M54 to M6 Link Road
TR010054

**8.8 LIU(I) Draft Statement of Common
Ground with Ian Simkin & Adrian
Simkin**

January 2021

Drawing Number HE514465	Originator -GHX	Volume -LLO	Rev P08
Location Z2_SW_PR_Z	Type -DR-LR-1005	Role -DR-LR-1005	Number P08

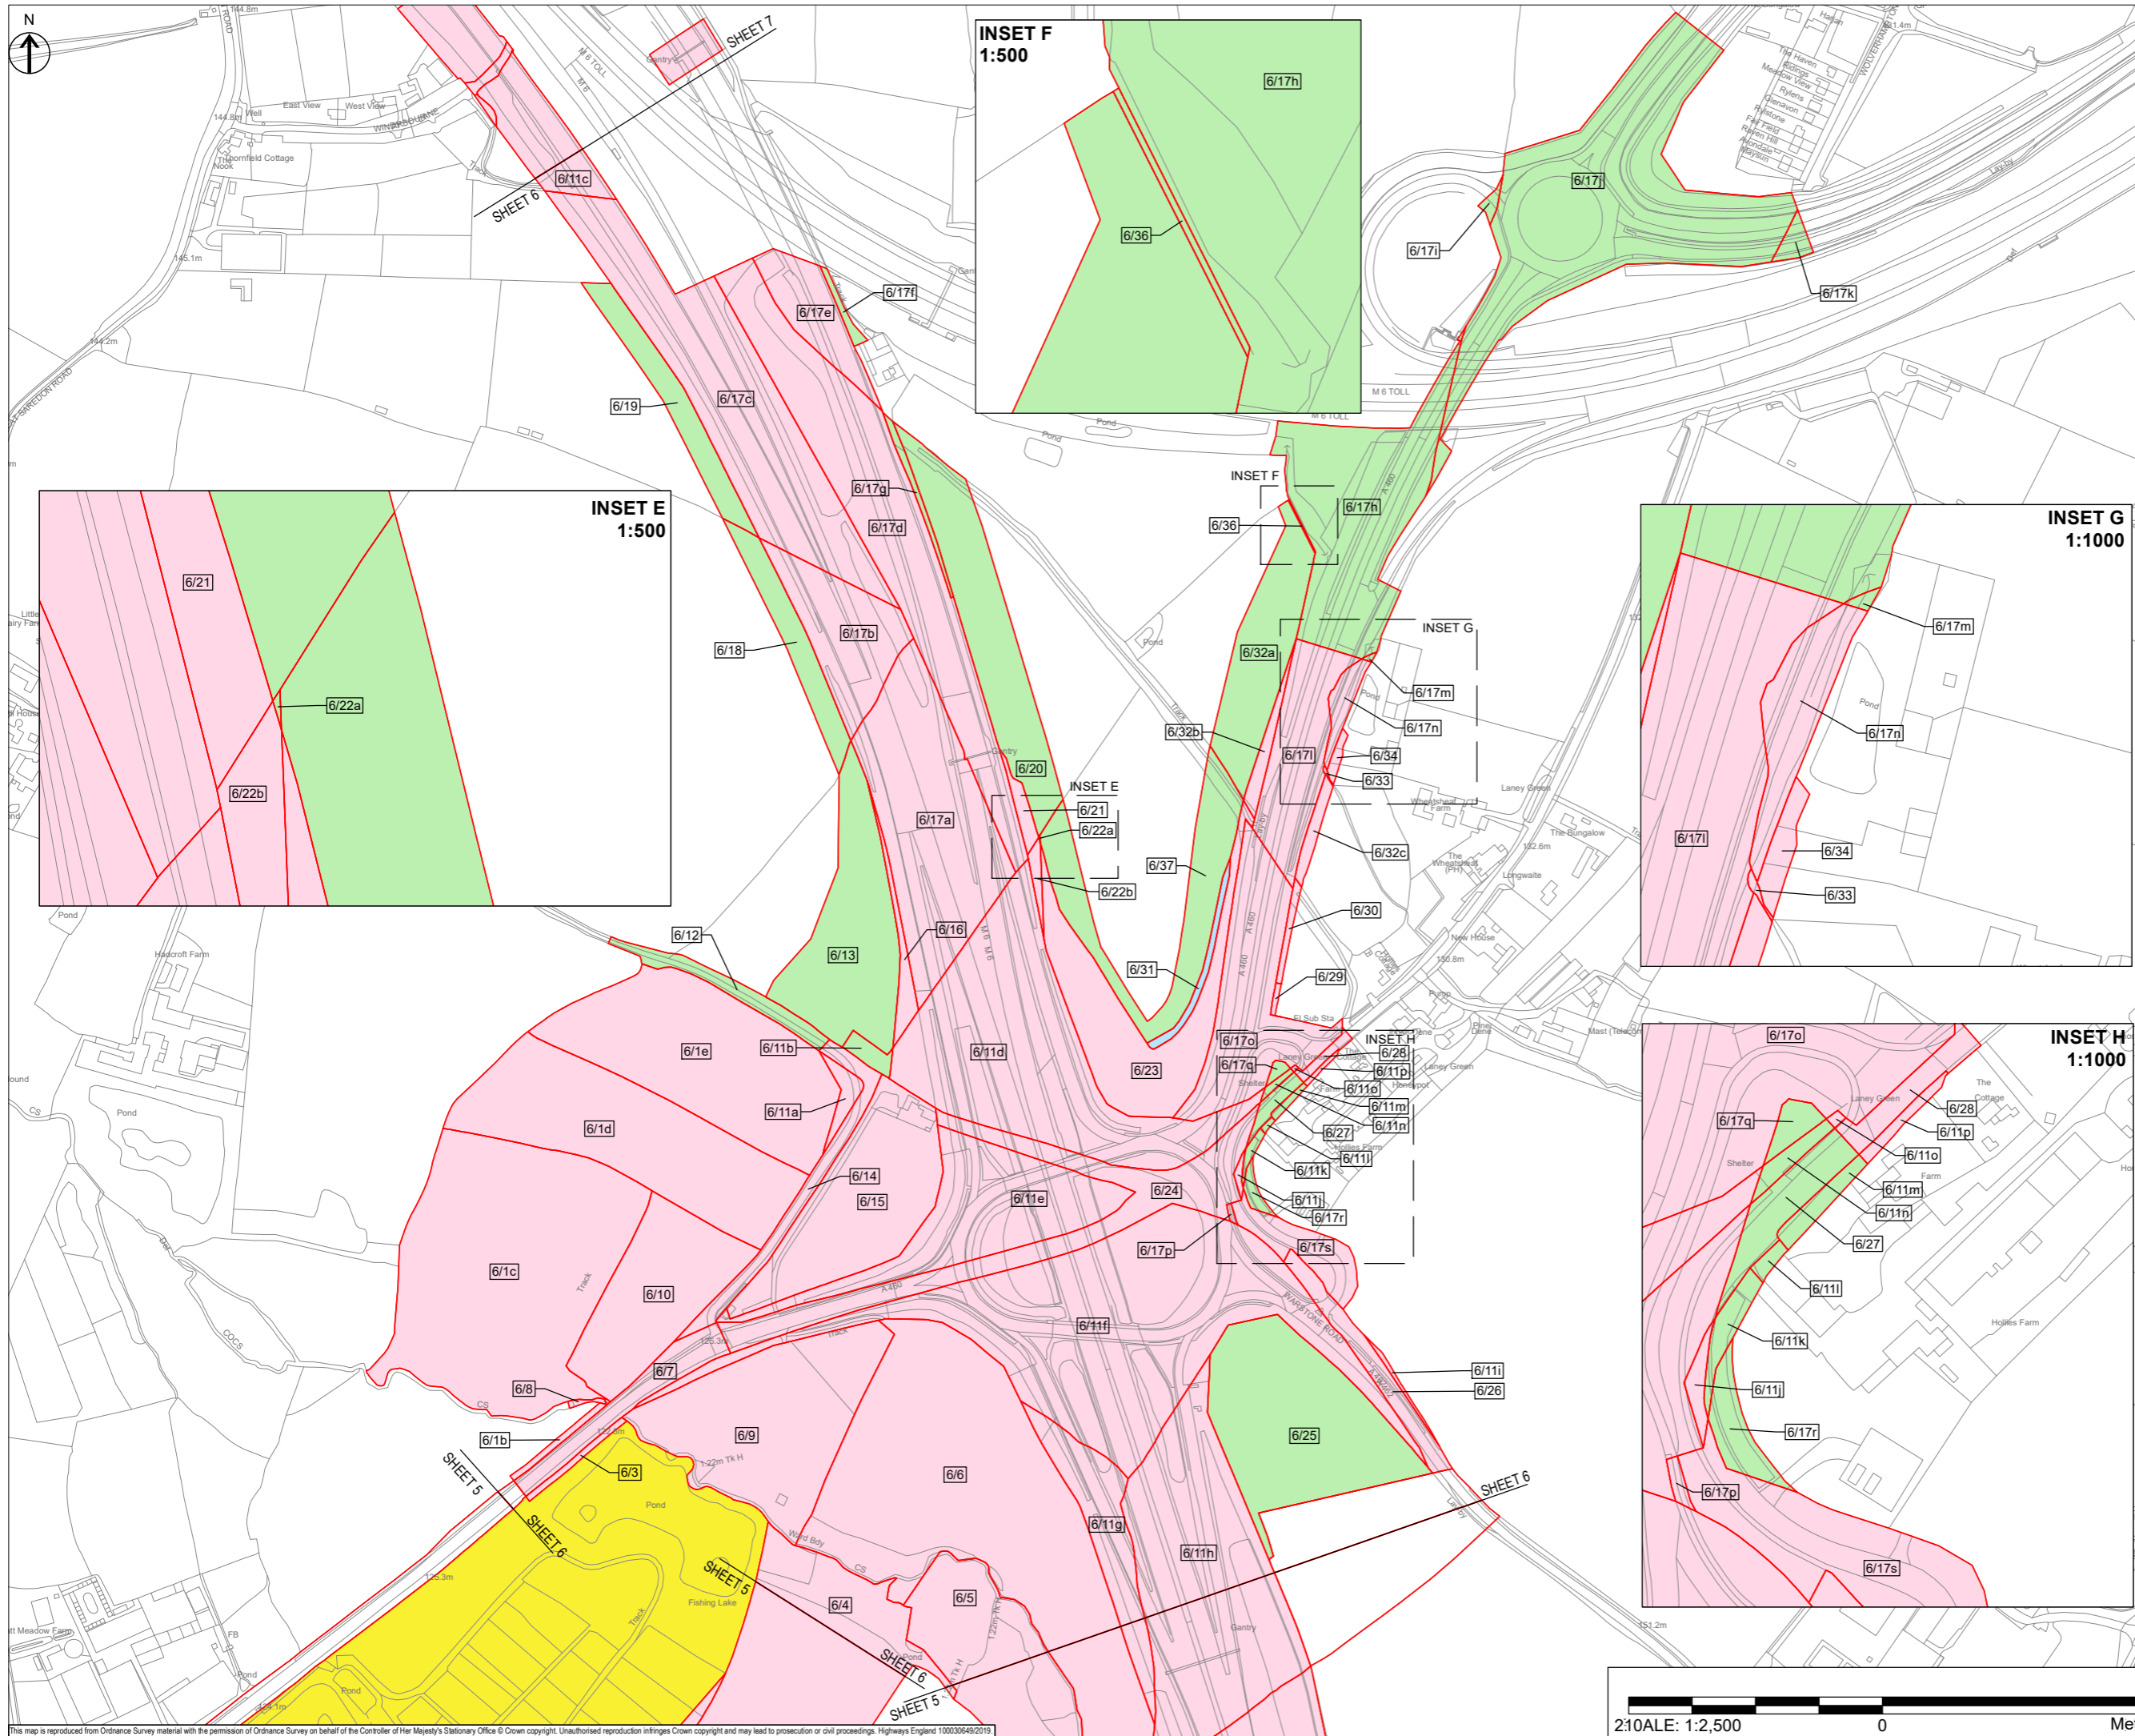
<p>The permanent acquisition of plots 5/26, 5/27, 6/25 and 6/23 for environmental mitigation is objected to as it is considered excessive for the offsetting of only approximately 0.79 ha of arable land being taken for the road construction and we do not accept that the extent of the land proposed to be taken for mitigation, at 3.504 ha, is necessary and proportionate for environmental mitigation.</p>	<p>of the Scheme, HE has proposed to change the Environmental Masterplan [proposed changes versions AS-086 to AS-092/6.2] so that environmental mitigation is no longer present on these plots and plots 5/26 and 5/27 and the majority of plot 6/25 (as indicated on [AS-065/2.2]) are therefore not required to be acquired on a permanent basis. The northern part of plot 6/25 (as indicated on [AS-065/2.2]) is still required; part of which is required permanently for construction of the M6 Junction 11 and part of which is required temporarily for soil storage during construction. This temporary section would be reinstated to its previous condition and returned to the landowner after construction.</p> <p>One reason that this land was selected for removal from the Environmental Masterplan was in recognition of its status as Best and Most Versatile (BMV) agricultural land as highlighted by Messrs Simkin' representation made on 28/01/2020 as well as Natural England.</p> <p>An error identified with the Land Plans [AS-065/2.2] has been corrected, with the change accepted into the</p>

<p>eastern section of my client's land at plot 6/25. In addition, we welcome the removal the species-rich grassland habitat creation across the whole plot, following the review of the extent of mitigation across the scheme. On review of the Environmental Masterplan overview revision plan, the remainder of plot 6/25, which remains to be acquired temporarily, has an unexplained outlined area within, absent of a reference to it on the legend. Therefore, we cannot comment any further until such time as clarification of what the pink outlined area represents is provided to us, which was requested from HE on the 7th September 2020.</p>	<p>Environmental Masterplan issued with the Scheme changes on 9 October 2020.</p> <p>As recognised by the landowner, the area covered by plot 6/25 located to the south-east of M6 Junction 11 is proposed to be significantly reduced by the Scheme changes. This means that plot 6/25 is significantly smaller on the revised Land Plans submitted on 9 October 2020 than in the current Land Plans [AS-007/2.2].</p> <p>Clarification on the purpose of the area outlined in pink/ purple was provided via email to the land agent on 14/09/ 2020. It was also annotated on the plan published on 24 August showing the changes to the Masterplan (comment EM3).</p>

Examination on 7 January 2021. The revised Land Plan is document [AS-127/2.2], and shows the area of the northern section of Plot 6/25 (as indicated on [AS-065/2.2]) as permanent acquisition plot number 6/38.			
Land agent's Relevant Representation RR-033	If it is held that land has to be taken for environmental mitigation, then we would welcome the opportunity to discuss terms of the retention of the freehold, but subject to a management agreement for the management of the land in an environmentally beneficial way to help satisfy environmental mitigation requirements of the scheme.	The design changes submitted on 9 October 2020 were accepted by the Examining Authority on 29 October 2020, therefore no land owned by Ian and Adrian Simkin would be permanently acquired for the sole purpose of environmental mitigation.	Agreed	Agreed	Agreed	
Land agent's response to the consultation on changes to the DCO	(With regards to Change 7) We agree with the proposed reduction in order limits at this location, which removes the south	The Environmental Masterplan published for consultation on 24 August 2020 showed a pink/ purple outline on plot 6/25. This area would be used for temporary soil storage during the construction of the Scheme. This boundary is not shown on the	Under discussion	High	High
